20 April 2018

**Goulburn Mulwaree Council Preliminary Comments
Goulburn Base Hospital Redevelopment
130 Goldsmith Street, Goulburn (Your Ref: SSD 8667)**

Goulburn Base Hospital Redevelopment

Client	NSW HEALTH INFRASTRUCTURE
Project	GOLDBURN HOSPITAL & HOSPITAL SERVICES REDEVELOPMENT
Title	HYDRAULIC SITE LAYOUT - OVERALL
Original Size	A1
Drawing No.	22-18102-H101
Rev.	A

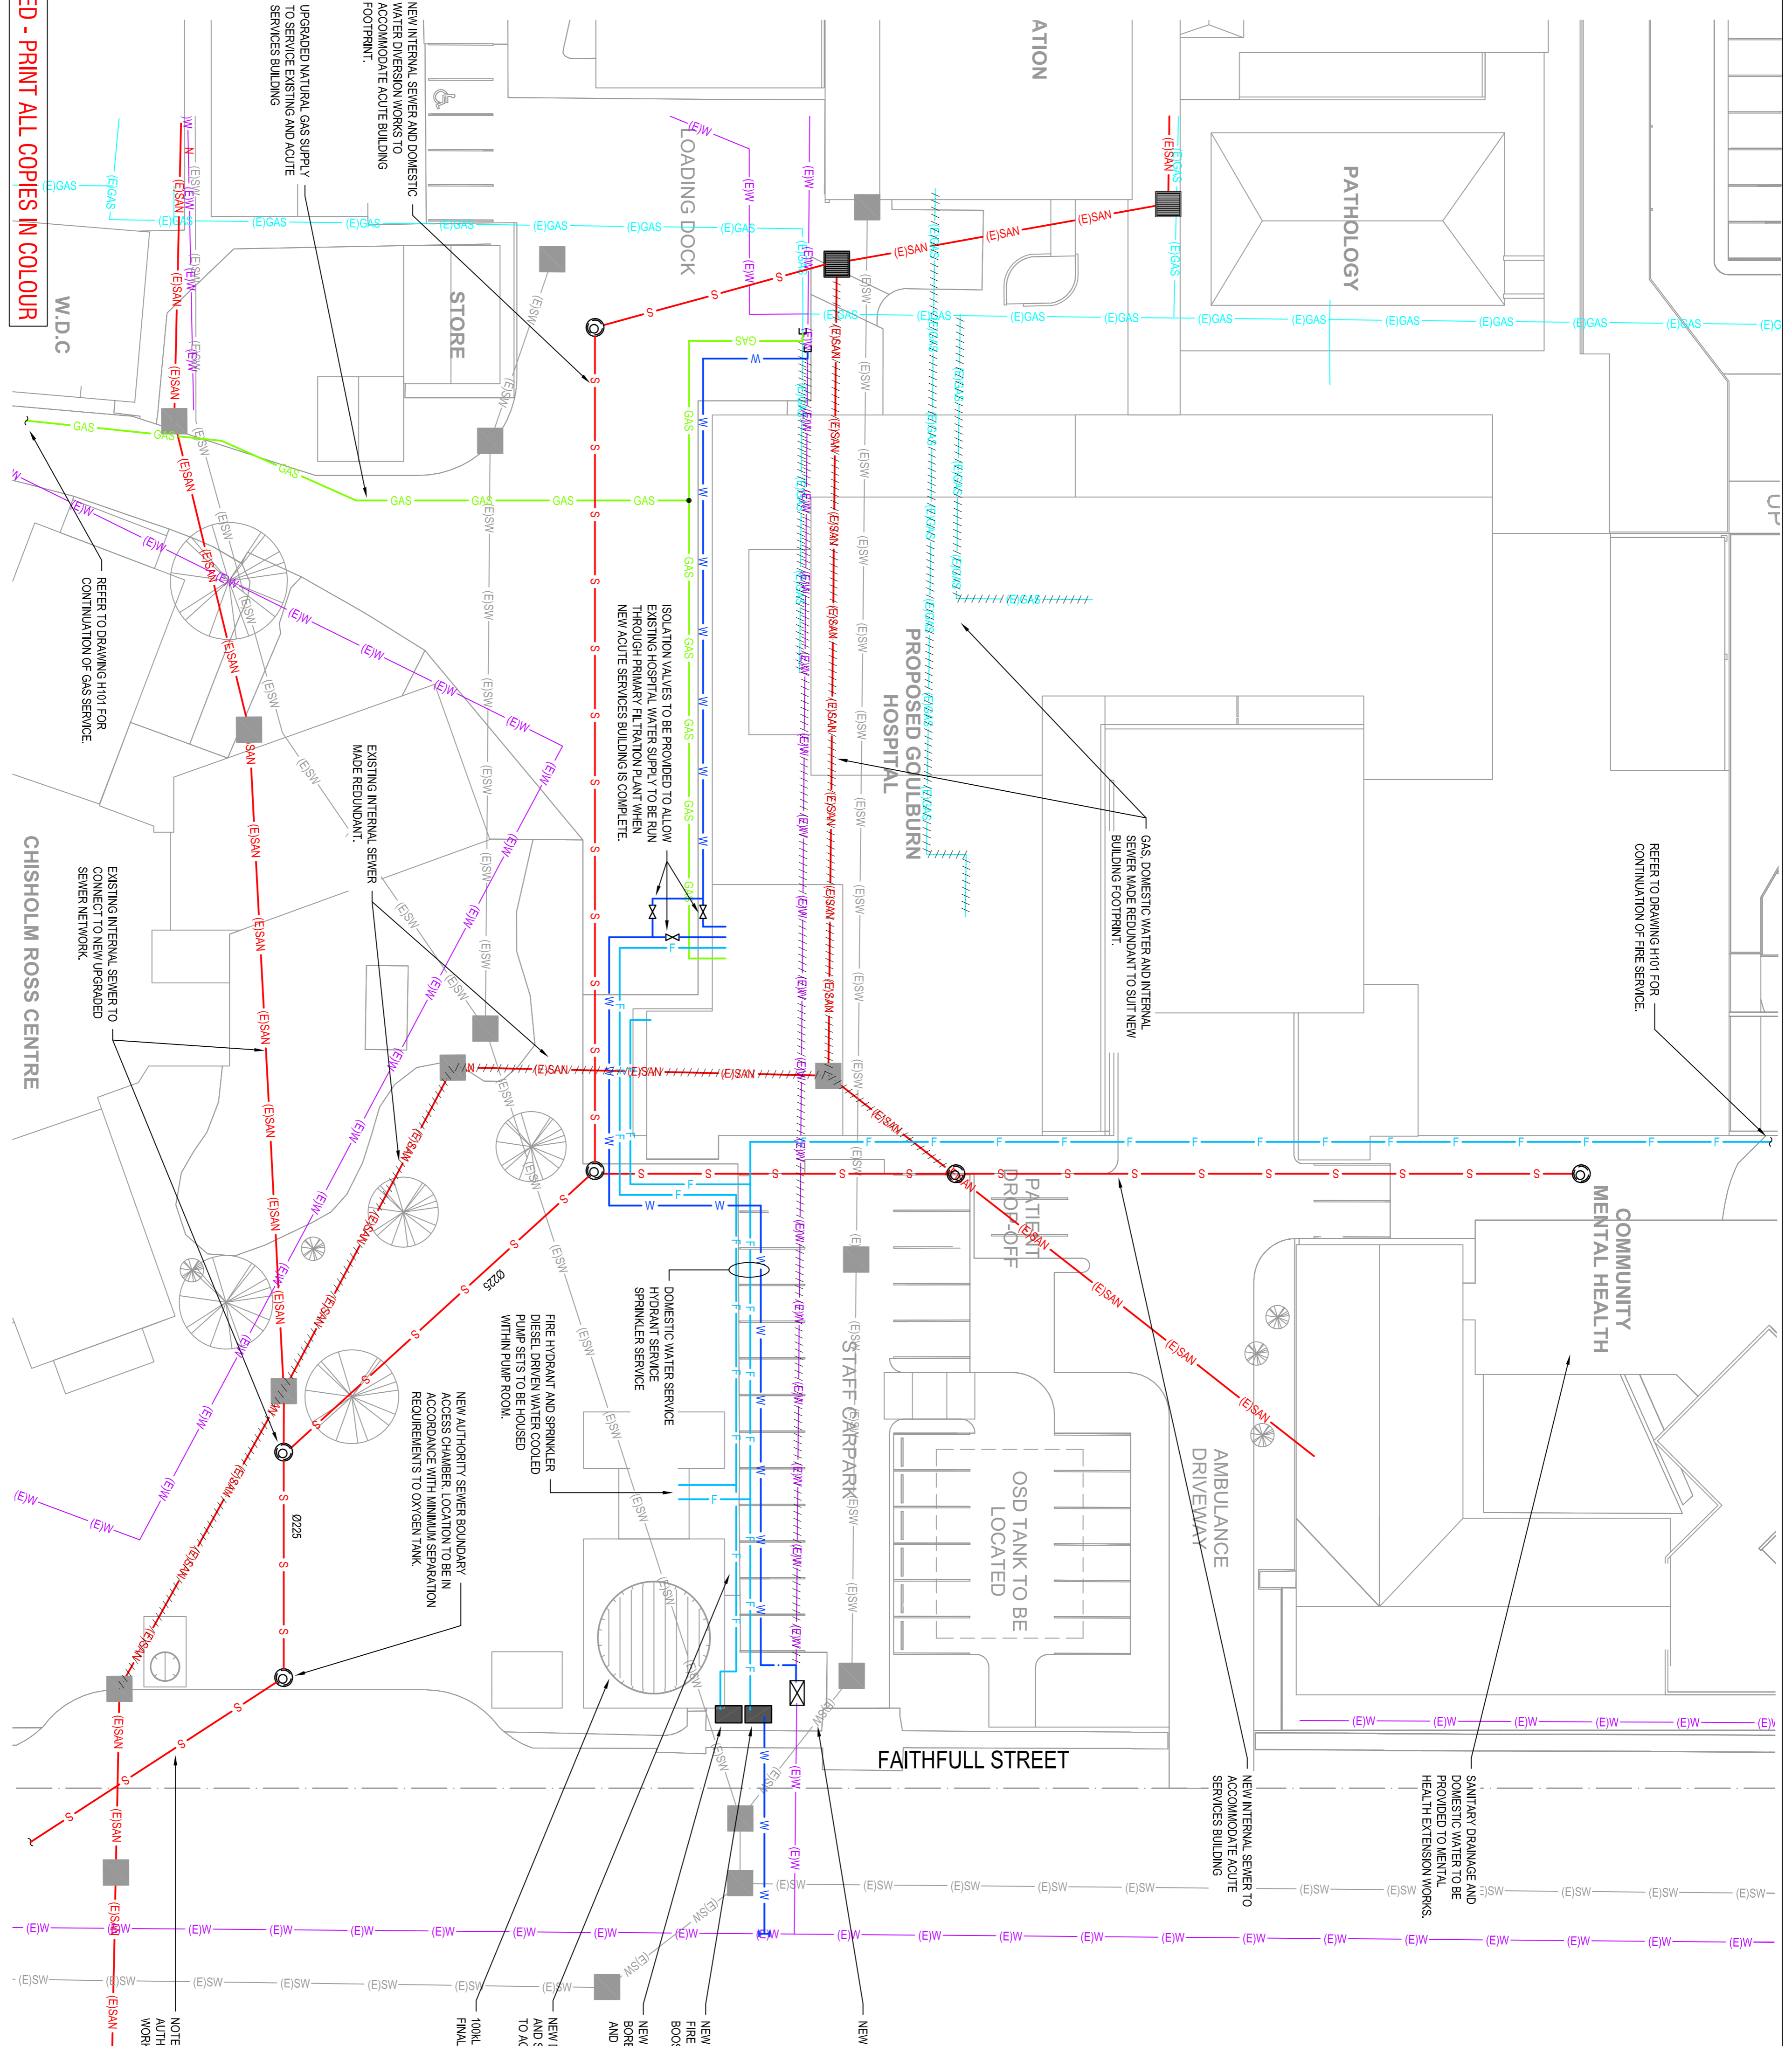
Document	Preliminary Comments
Appendix 14b – Hydraulic Services Plans	<p>Refer to Drawings H100, H101 and H102. Council will provide a quotation upon receiving an application for the following:</p> <ul style="list-style-type: none"> ▪ Disconnect & cap the existing 150mm fire service in Goldsmith St following commissioning of the new dedicated fire service off Faithful St. ▪ Install a new 150mm dedicated fire service from council's water mains to the property boundary in Faithful St, ready for downstream extension & installation of DCV with detector check meter by others
Appendix 15 – Landscape Plans – Part 1 - 5	<ul style="list-style-type: none"> ▪ The plans are professionally prepared and the analysis section is generally well considered. ▪ Page 104 mentions that there are areas of vegetation in the Goulburn region that contain River Red Gums. This is not the case. The relevant species found with Yellow Box is likely to be Blakely's Red Gum e.g. Eucalyptus blakelyi. River Red Gums are not sufficiently frost hardy to survive locally. ▪ The original hospital buildings are heritage listed and have a formal symmetrical layout albeit that asymmetric, unsympathetic additions have been added over the years. The proposed landscape design doesn't respect the formality of the original hospital. ▪ Arcadia plan page 120 > Detail Plan – Old Entry. ▪ The area in the immediate vicinity of the Goldsmith St frontage of the original Manfred designed buildings and including the crescent shaped driveway should be handled in a more formal way. This can then morph into the informal sensory garden proposed in the Northwest corner of Goldsmith and Albert Streets. The design is relevant to the area generally but not necessarily the hospital site specifically. ▪ There should be no planting directly against the historic buildings as this will have a negative impact on the buildings footings via increased water movement. A space of approx. 2.0m should be left with a suitable gravel surface layer. ▪ As noted below the existing Phoenix canariensis, Canary Island Date Palm should either be retained in situ or transplanted to a location as close as possible to its existing position for example in the proposed entry to the new building. ▪ Arcadia plan page 119 > Detail Plan – Main Pedestrian Entry. ▪ There is insufficient planted area to reduce the visual impact of the new buildings and expansive paved parking areas proposed. Additionally more shade trees should be used. This is particularly so for the uphill/western side of the entry 01 and the parking area off Albert Street. <p>Forwarded the Landscape Design Report to Louise Thom regarding the suitability of the informal design adjacent to the original heritage buildings</p> <p>The plan proposes the removal of the Eastern Wing of the original Manfred design. This is a significant impact on the fabric of the site. (See attached)</p>
